20150617.1/0302A/R0/TT

03/02/2016

Business Hub, Fifteenth Ave, West Hoxton - Response to EPA Queries

We have been asked to respond to comments provided by the EPA in their letter of 27 November 2015 with respect to our acoustic assessment of the above site (*Operational Noise Impact Assessment* – dated 1.7.2015, Rev 2).

Bankstown & Liverpool (Weather Removed From Calc): Sunday 24 May, 2015

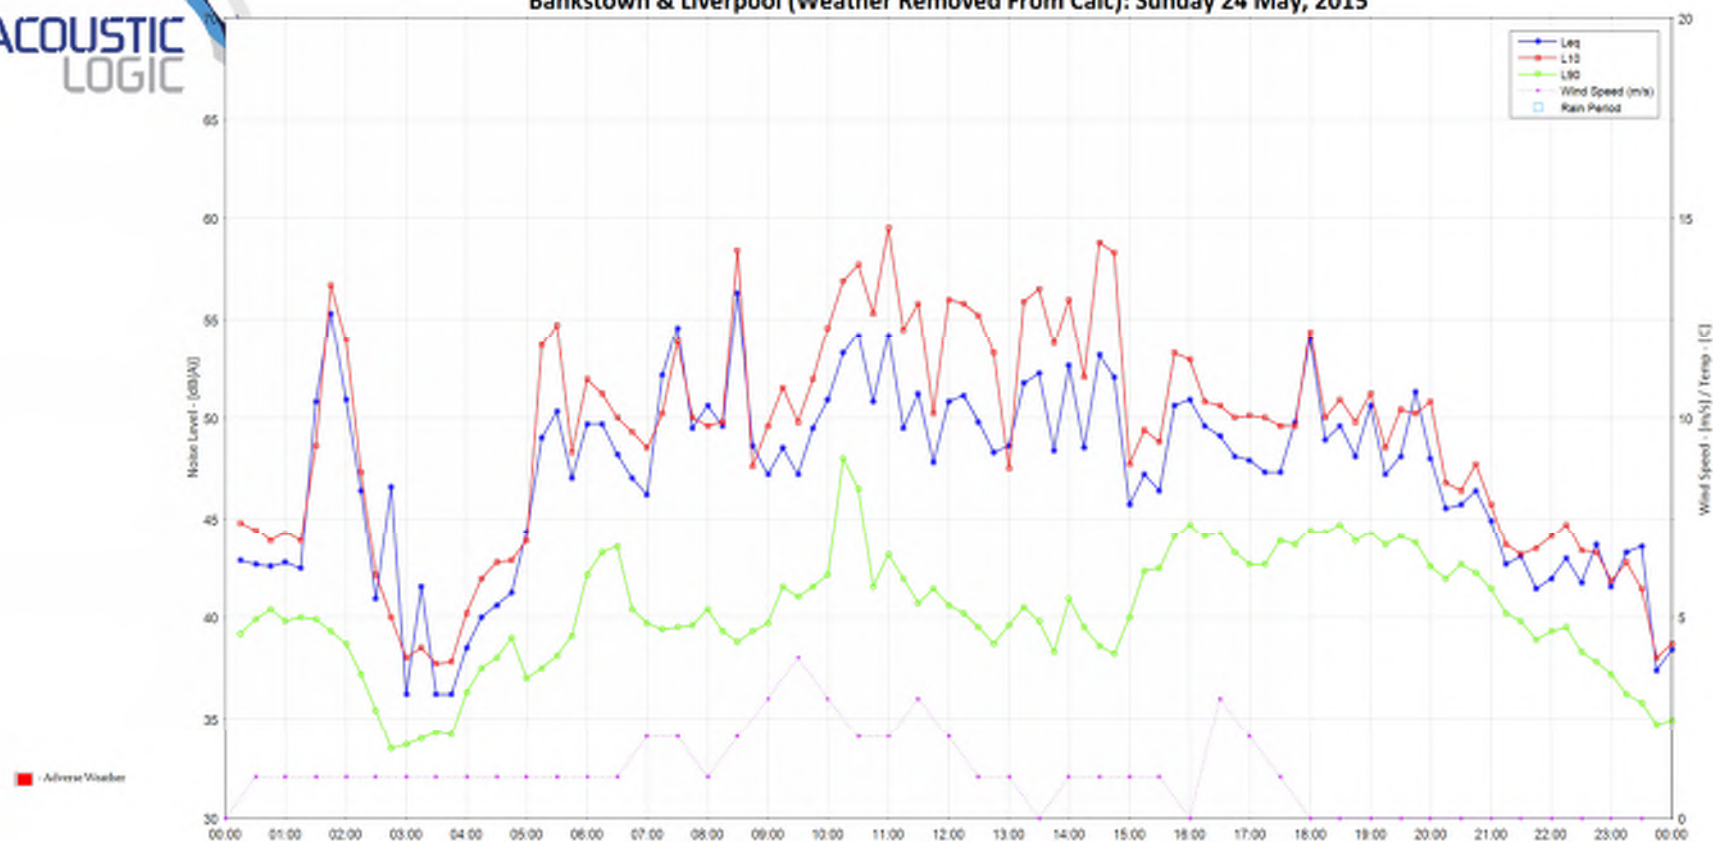
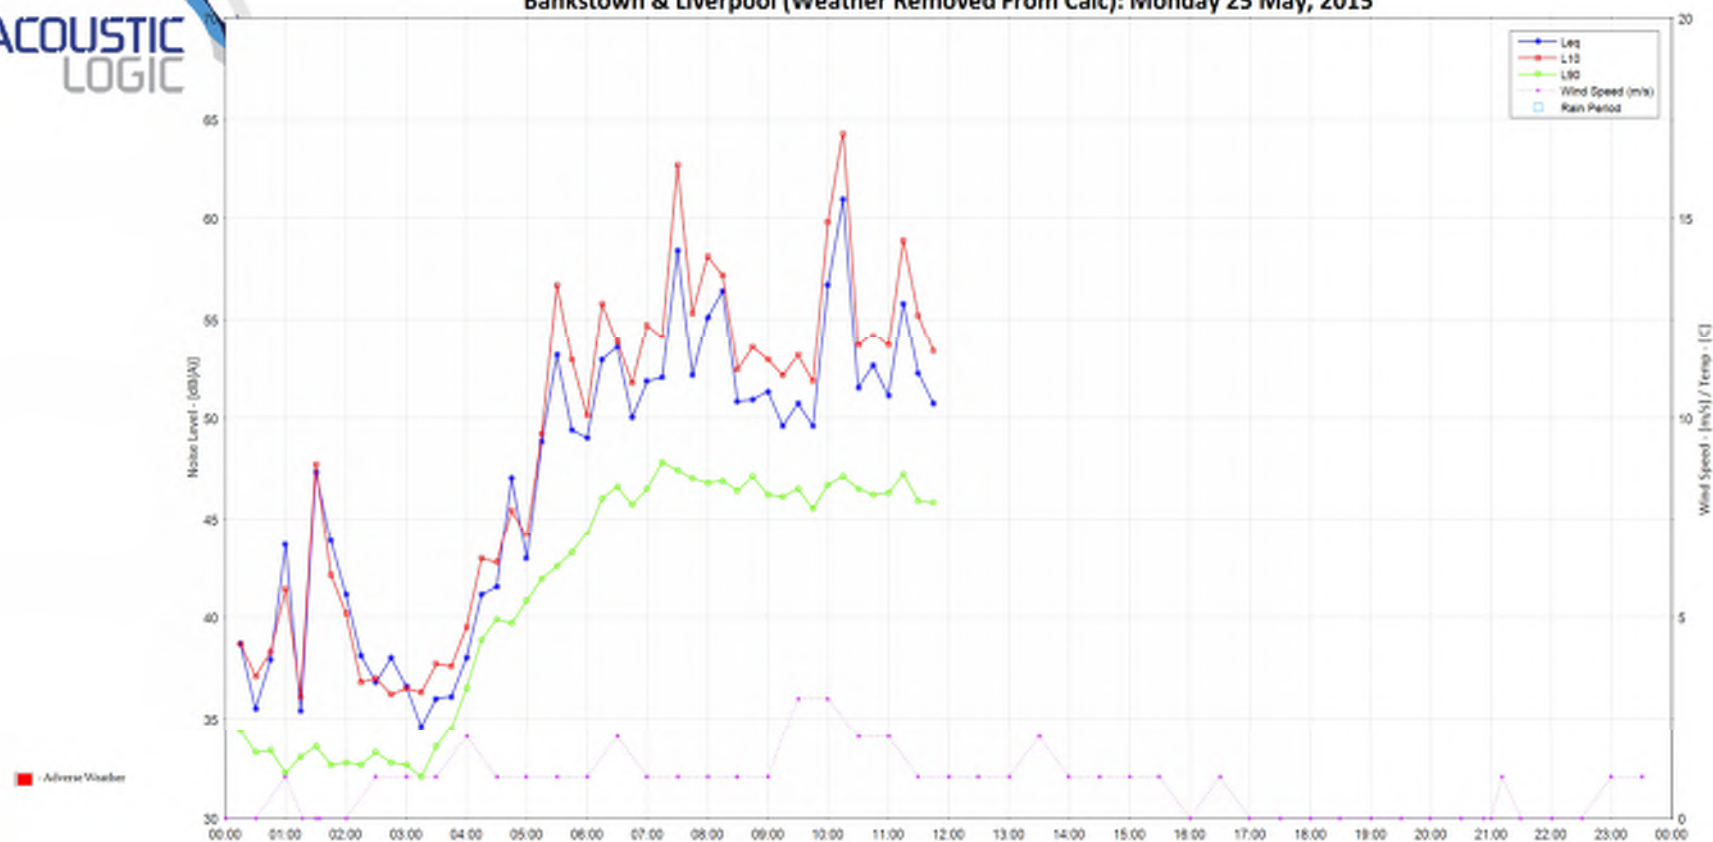
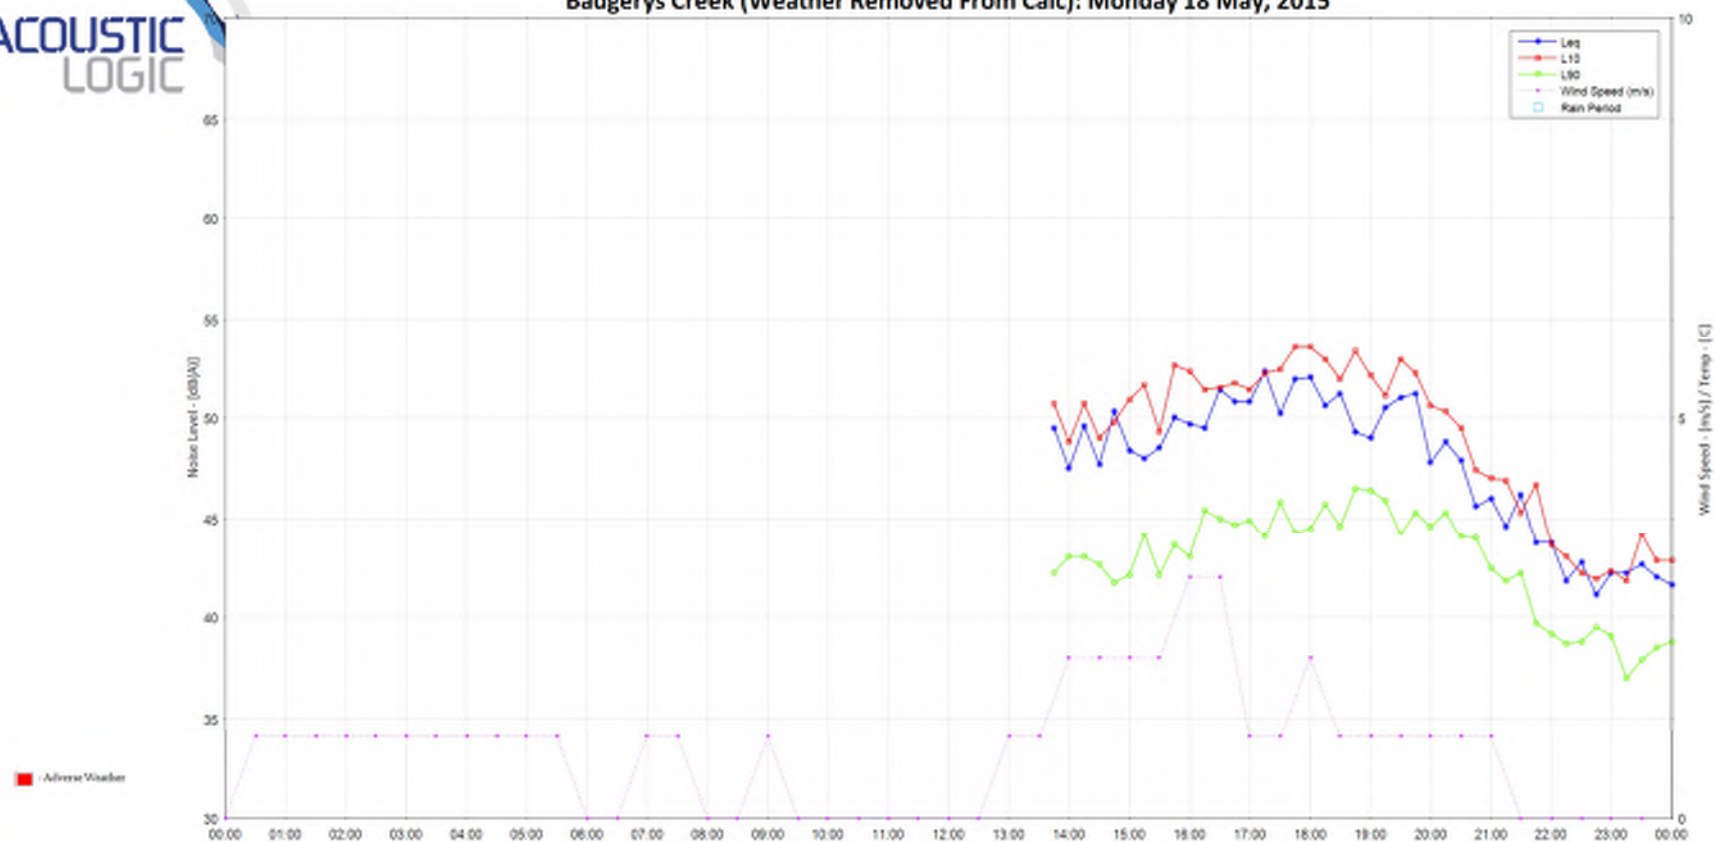
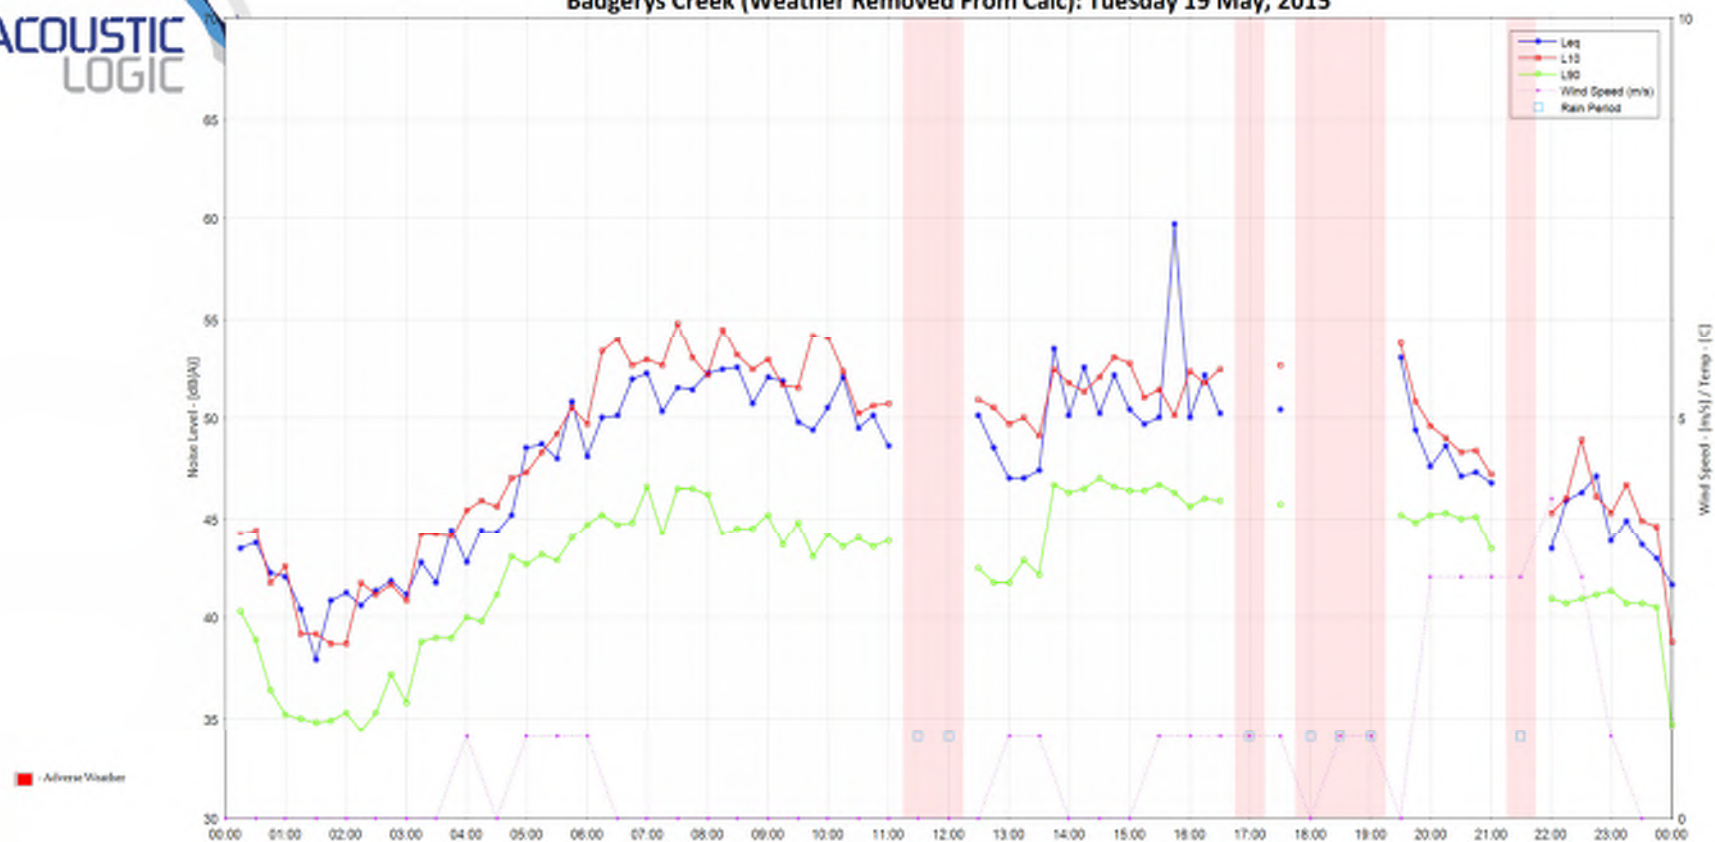
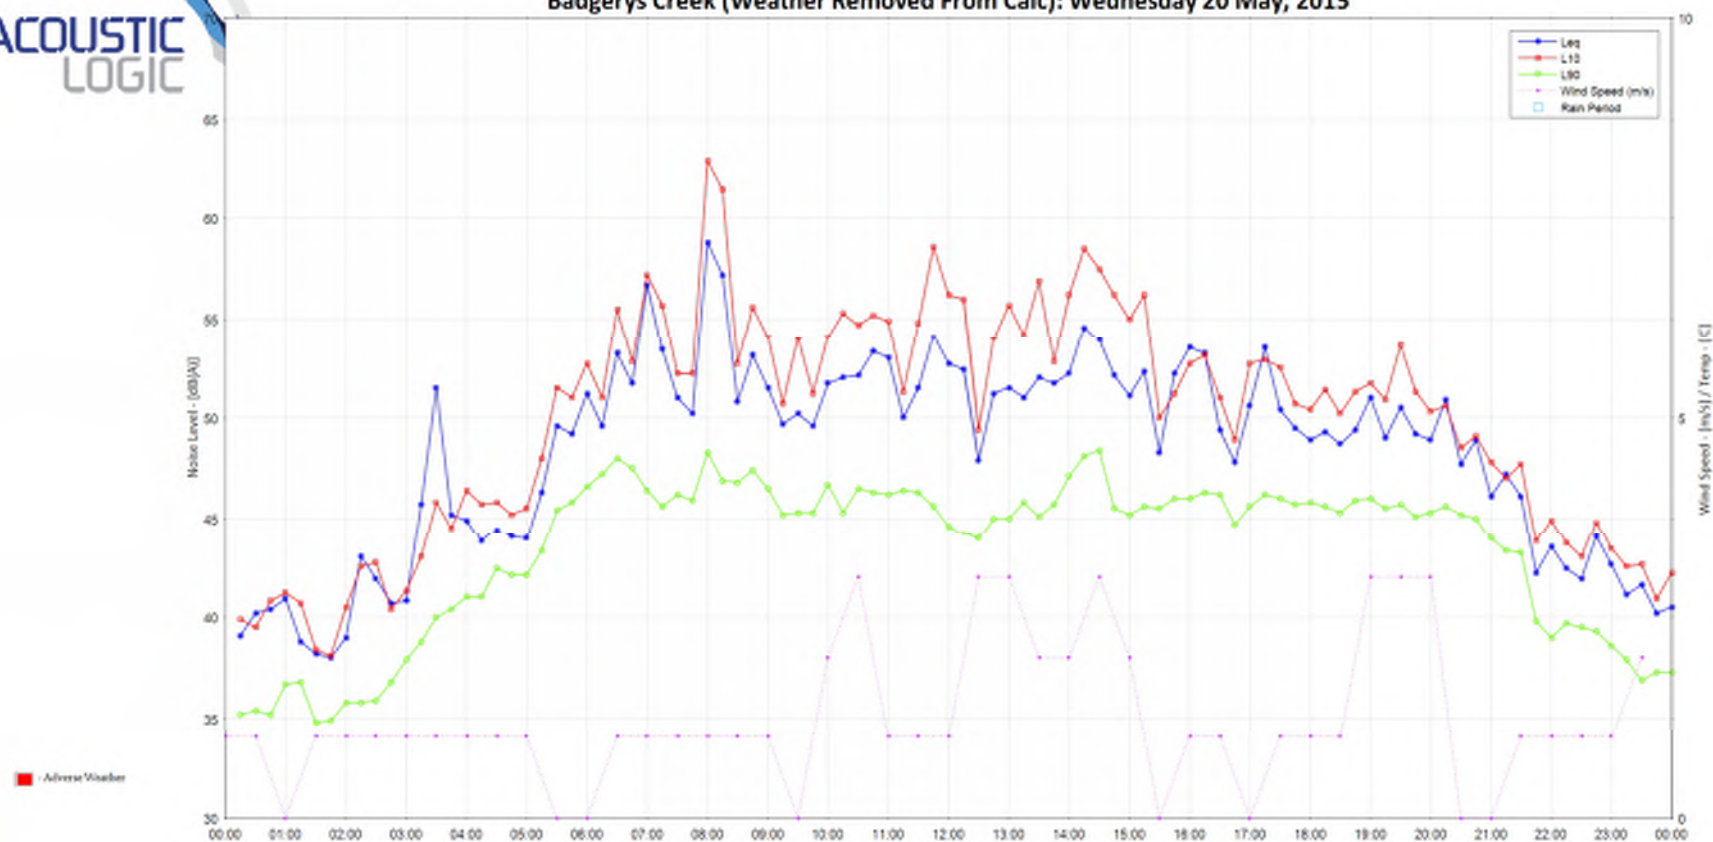
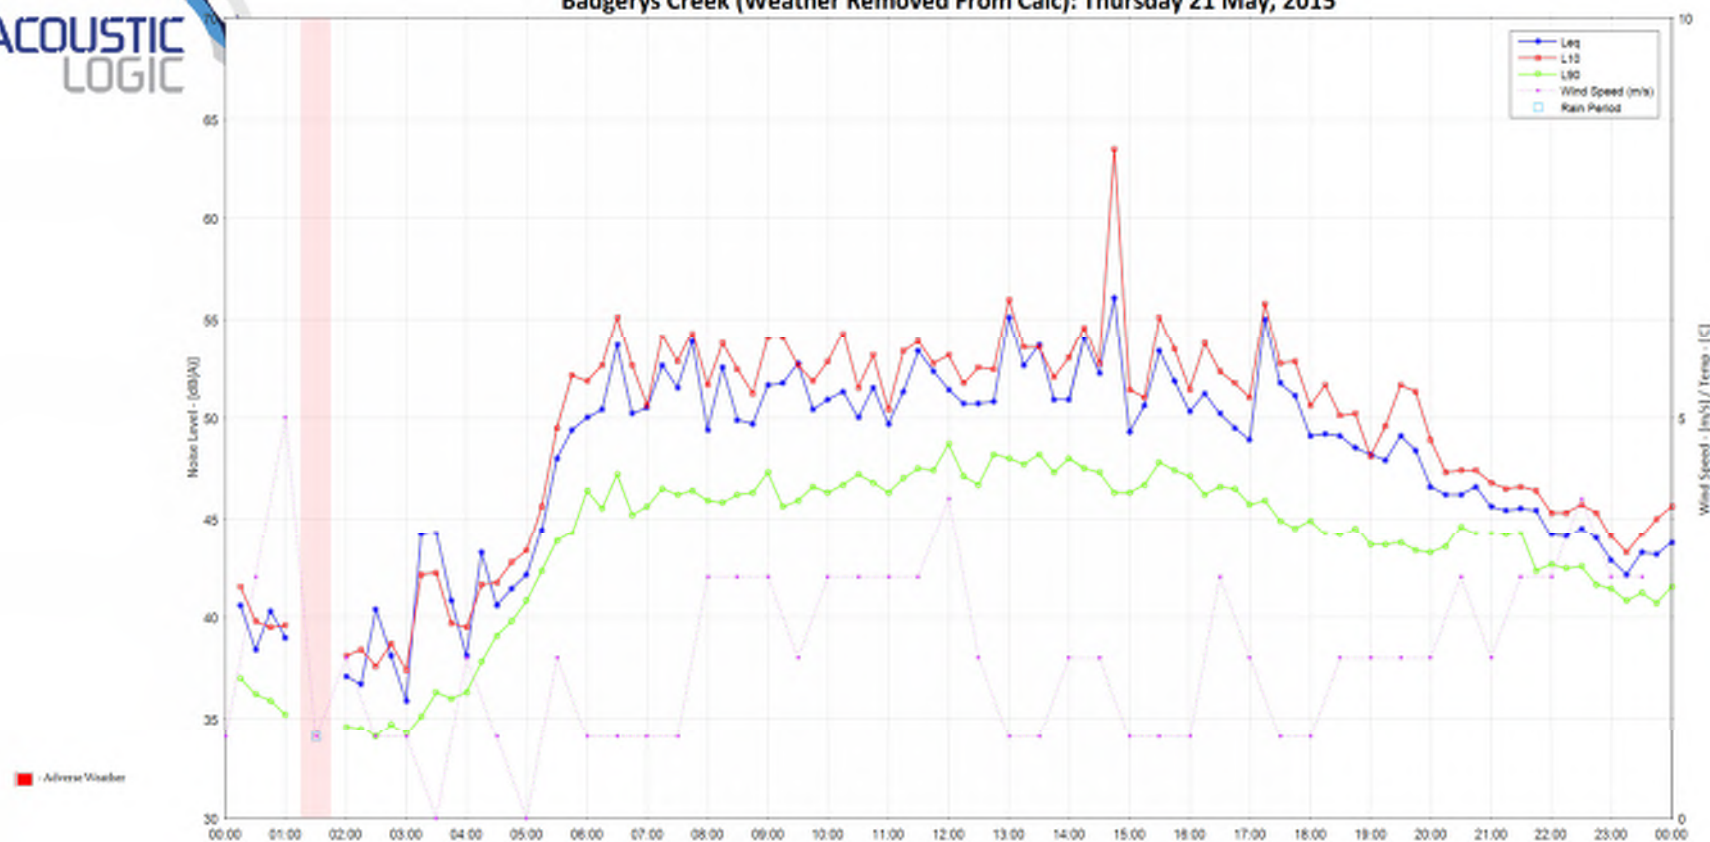
- The fact that metrological data used by them is different to that used by ALC in determining background noise levels in our report.
- The EPA has referred to a number of “wind gusts” which should have resulted in that periods of noise logging being omitted when determining background noise levels.
- The EPA has concluded that due to the fact that there are periods of the logging which are weather effected, that the logging should be re-done.

- With respect to the EPA reference to wind gusts exceeding 18 kilometers per hour on each day from 18 to 23 May, this is in fact irrelevant. Section 3.4 of the Industrial Noise Policy refers to *average* wind speeds for entire 15 minute periods as being the criteria for determining whether that period of data is to be excluded. A short duration wind gust is not relevant, only the average wind speed is. It is the *average* wind speed which was used by ALC in determining Rating Background Noise Levels, which is consistent with EPA practice.

- As a precaution, background noise levels were determined using both the Badgery’s Creek and the Bankstown Airport weather data. The same rating background noise level was determined regardless of the weather data used. Both sets of meteorological data are included in the amended *Operational Noise Impact Assessment*.

- When viewed over an entire one week period, the duration of weather effected data is very small (only one relatively prolonged period with adverse weather occurring during the daytime on 22 May 2015). Other periods were one hour duration or less.

Noise logging data was processed in accordance with EPA guidelines with respect to the impact of adverse weather. The weather data used for assessment was taken from a nearby weather station. Given the overall short duration of weather impacted data, the Rating Background Noise Level used for assessment is accurate.
